Date: October 13, 2025

Re: 25-FRM-222
Roof Truss Repairs
9006 Christian Light Rd.
Fuquay Varina, NC 27526
Permit No.: SFD2411-0036

At your request, a site visit was made to the above referenced address to inspect drilled roof trusses within the detached garage being converted to living space.

ROOF FRAMING PLAN

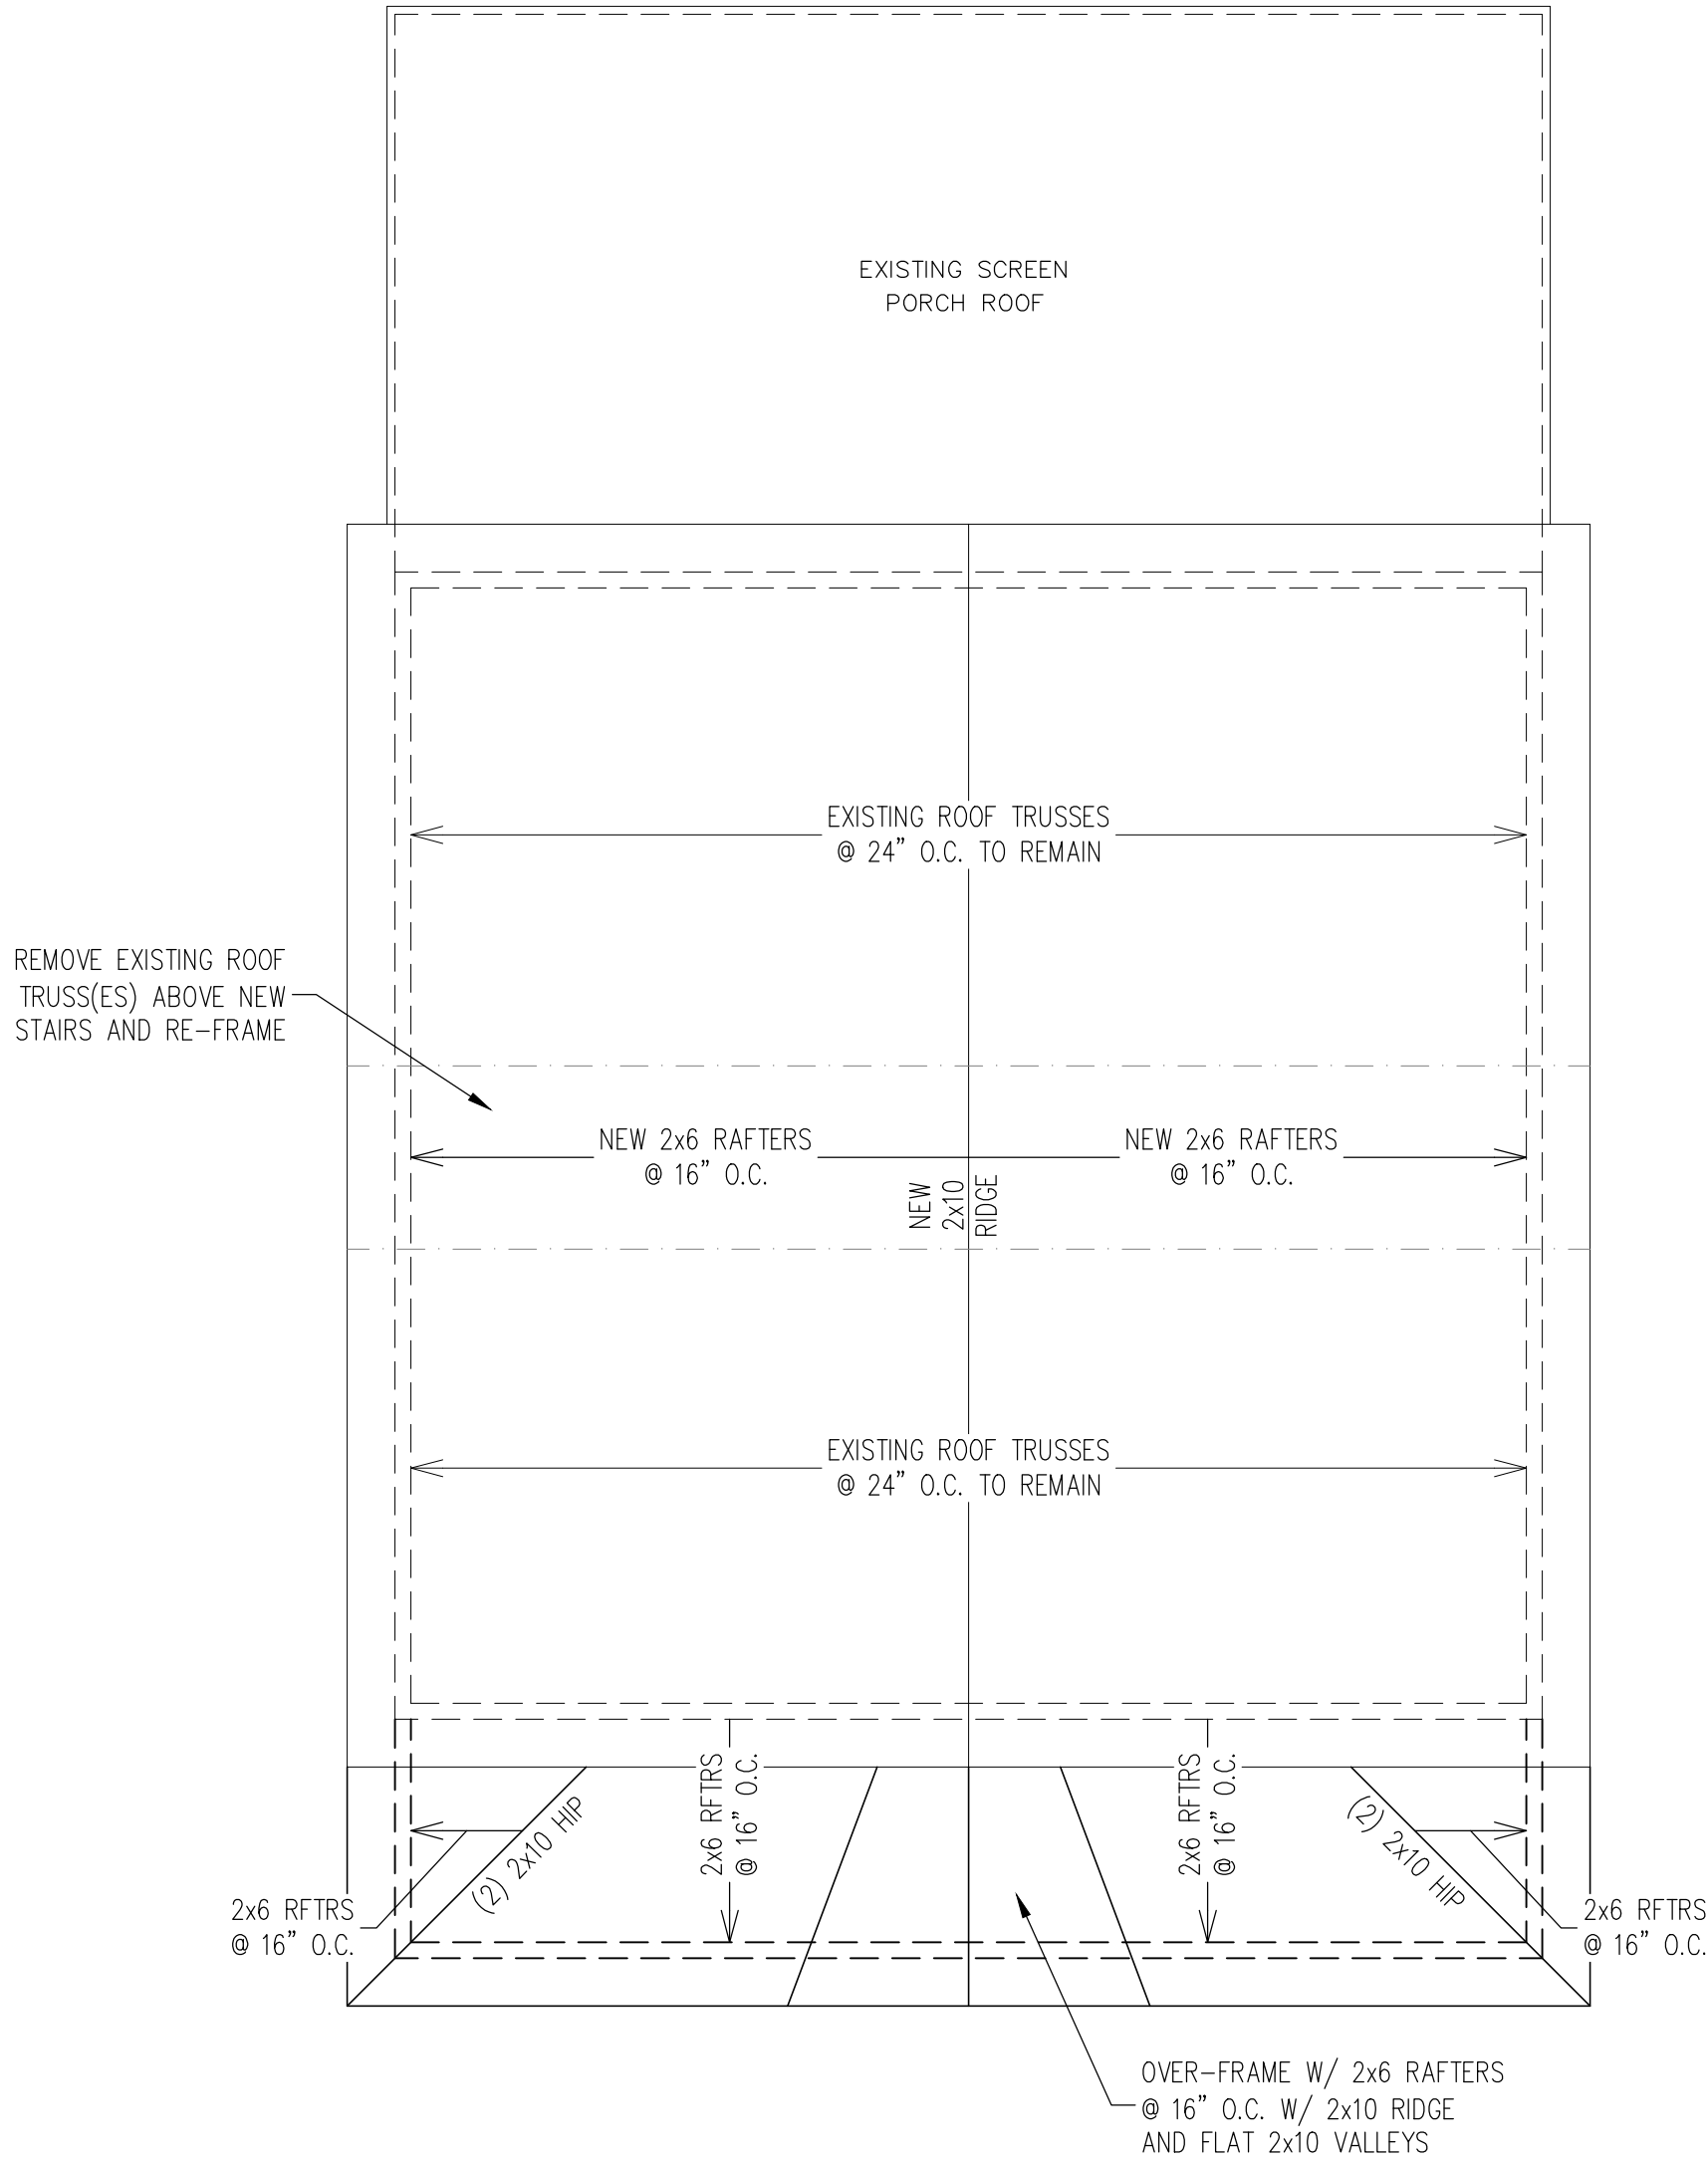
1. The 7th and 8th roof trusses from the front exterior wall had three $+/-1$ " holes drilled through the bottom chord $+/-5'-10$ " from the right exterior wall.

2. The 8th-11th roof trusses from the front exterior wall had two $+/-1$ " holes drilled through the bottom chord $+/-9'-0$ " from the right exterior wall.

3. The 9th roof truss from the front exterior wall had four $+/-1$ " holes drilled through the bottom chord $+/-12"-24$ " from the left exterior wall.
4. Additional holes were observed in the following locations:

- a. The 1st-6th roof trusses from the front exterior wall had one $+/-1$ " hole drilled through the bottom chord $+/-7$ " from the right exterior wall.

- b. The 7th roof truss had four additional $+/-1$ " holes drilled through the bottom chord, aside from the holes noted in Item 1. The holes are located between 7'-0" to 16'-0" from the right exterior wall.

- c. The 10th and 11th roof truss from the front exterior wall had one $+/-1$ " hole drilled through the bottom chord $+/-14$ " from the left exterior wall.

1. Reinforce both sides of the bottom chord of the noted roof trusses with a 2x6x3' long scab, extending from the right exterior wall. Fasten the scabs with (3) rows of 10d nails spaced 4" o.c. Stagger nails from each side to avoid interference.
2. Reinforce both sides of the bottom chord of the noted roof trusses with a 2x6x4' long scab, centered over the drilled holes. Fasten the scabs with (3) rows of 10d nails spaced 4" o.c. Stagger nails from each side to avoid interference.
3. Reinforce both sides of the bottom chord of the noted roof truss with a 2x6x4' long scab, extending from the left exterior wall. Fasten the scabs with (3) rows of 10d nails spaced 4" o.c. Stagger nails from each side to avoid interference.
4. The drilled holes noted above are not a structural concern and require no reinforcement.

Lumber for scabs is to be SPF #2 or SYP #2. The drilled roof truss bottom chords reinforced in the prescribed manners above will provide the required support for all imposed loads.
